DEADLINE 5

**SUBMISSION OF THE HISTORIC BUILDINGS AND MONUMENTS COMMISSION FOR
ENGLAND (HISTORIC ENGLAND)**

**FOR AN ORDER GRANTING DEVELOPMENT CONSENT FOR THE BOTLEY WEST
SOLAR FARM**

APPLICATION REF: EN010147

Project: AG1803	Sheet: Field 1.11
Date: November 2024	
Scale: 1 : 6500 @A3

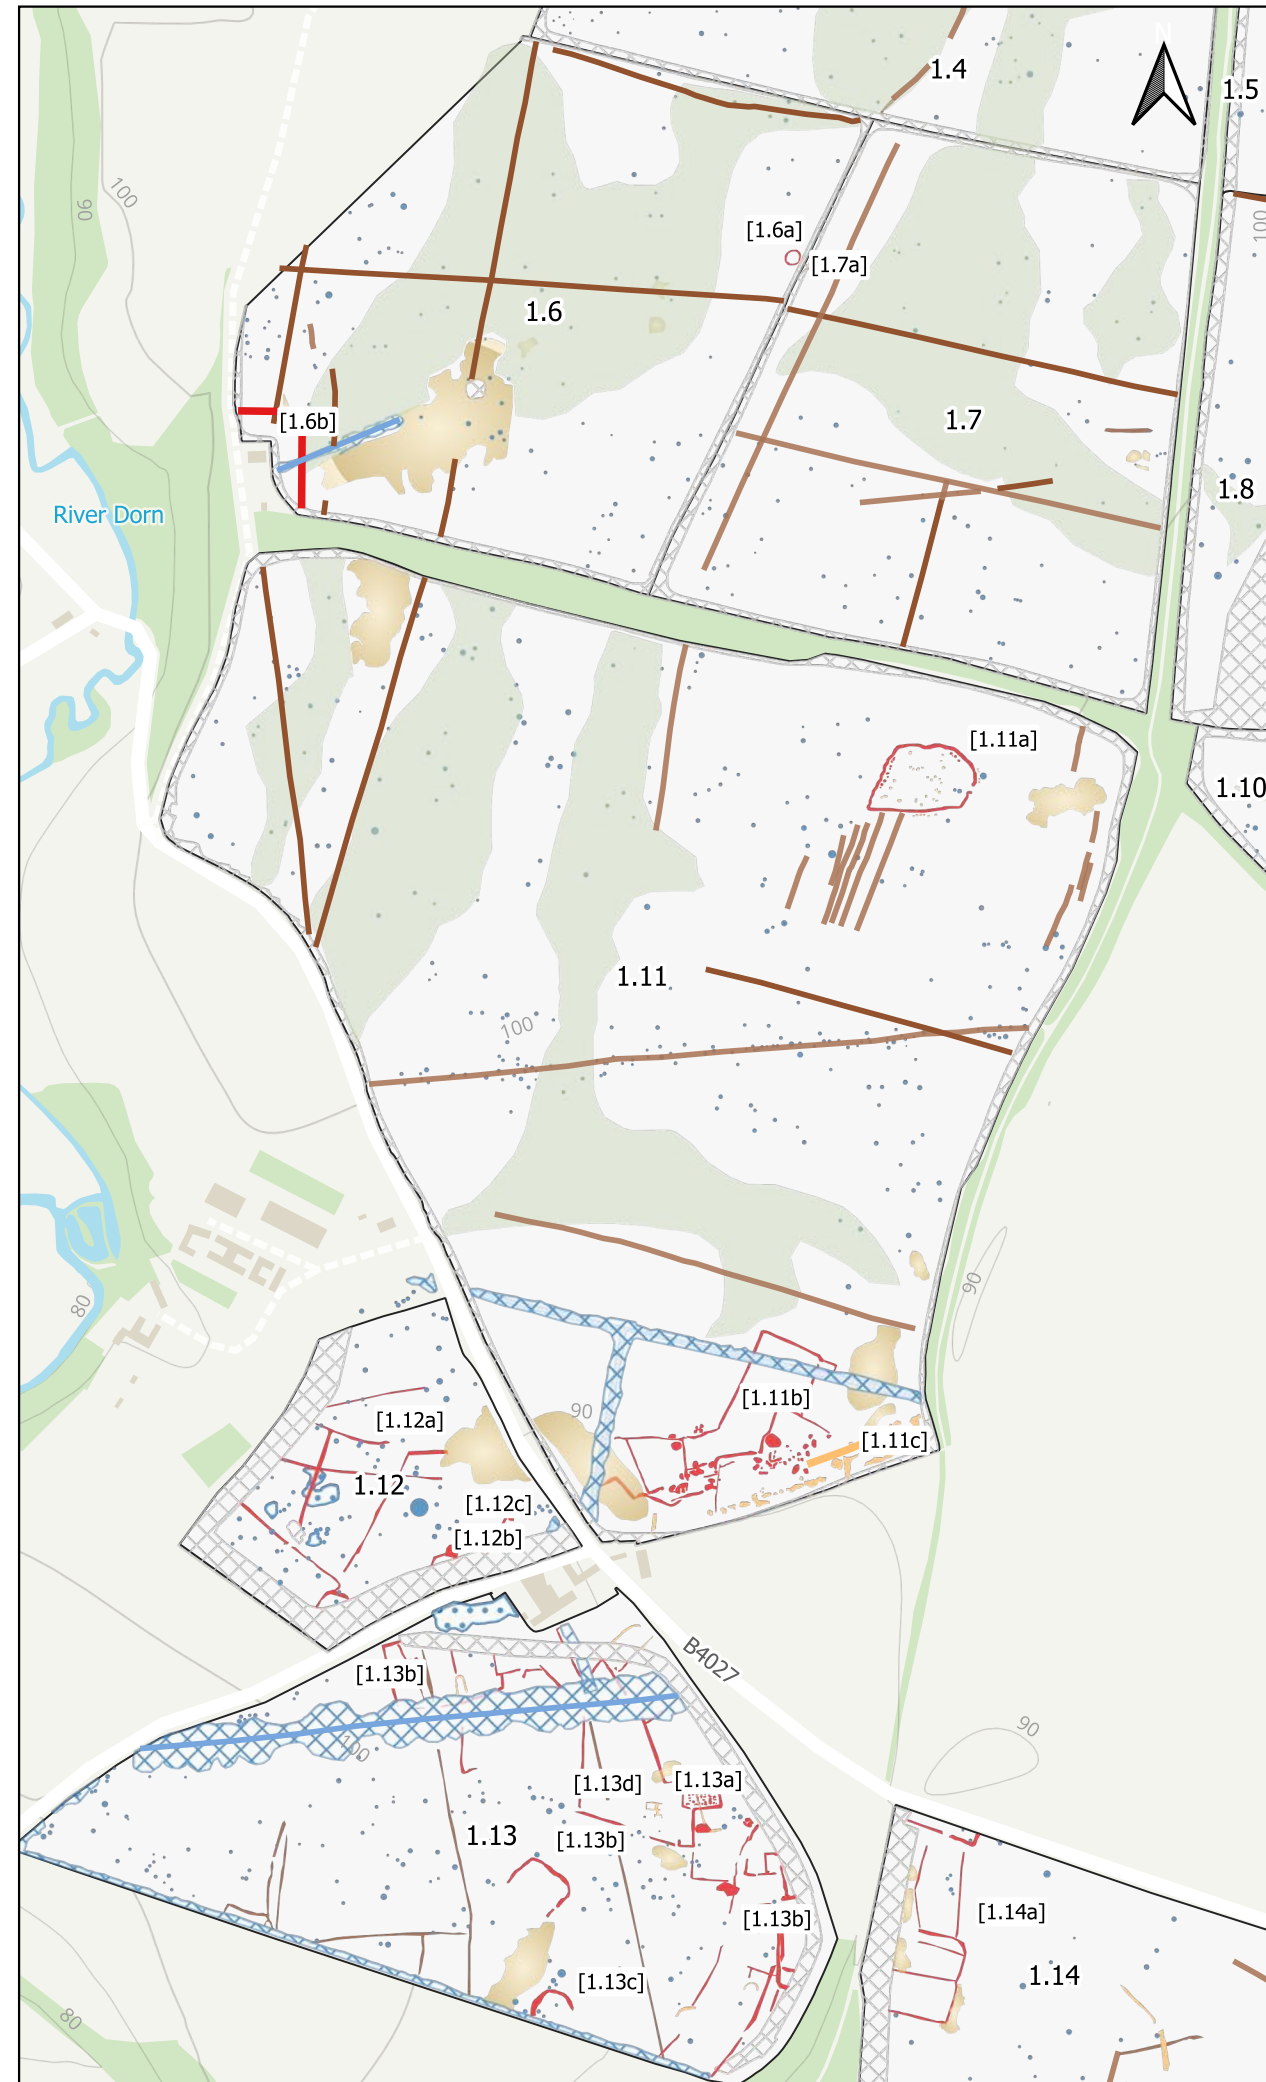
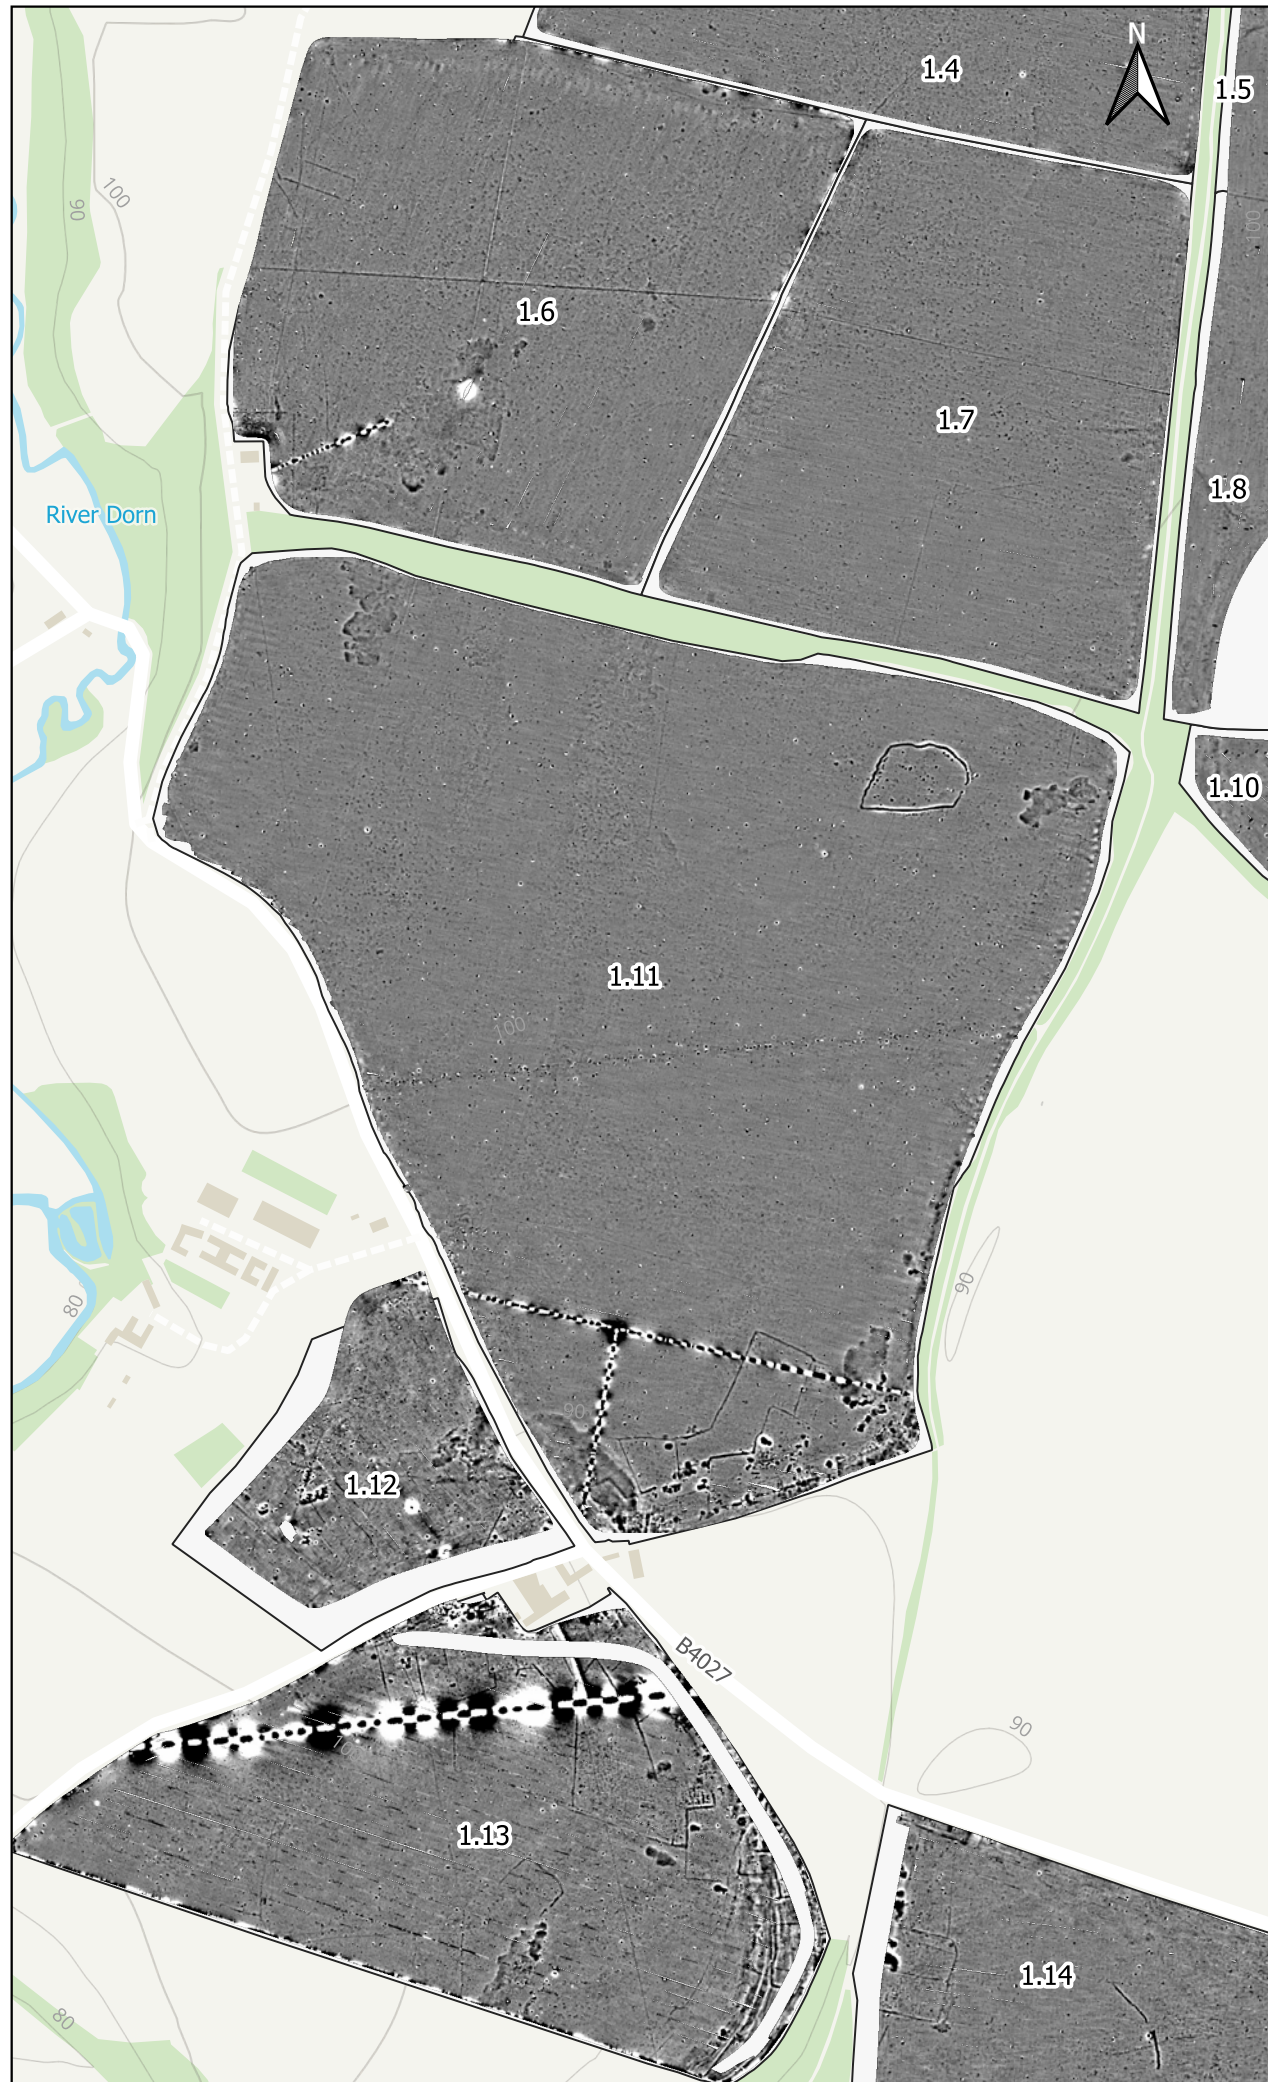
- a. Provide Historic England (and Oxfordshire County Council) with just the results of the trenches that were excavated in the fields that currently include the buffer zone (fields
-

1.11 – 1.14 in the geophysical report included with the Environmental Statement APP-134) in order that we can provide advice to help resolve this point before the determination of the DCO.

- b. Remove fields 1.12 and 1.13 entirely from the scheme and remove a greater proportion of field 1.11 and field 1.14. While it is (as we have previously stated) currently not possible to establish the boundaries of the Roman settlement, we believe that extending the buffer in this way is reasonably likely to reduce any harm to the potentially nationally important area to a minimum.
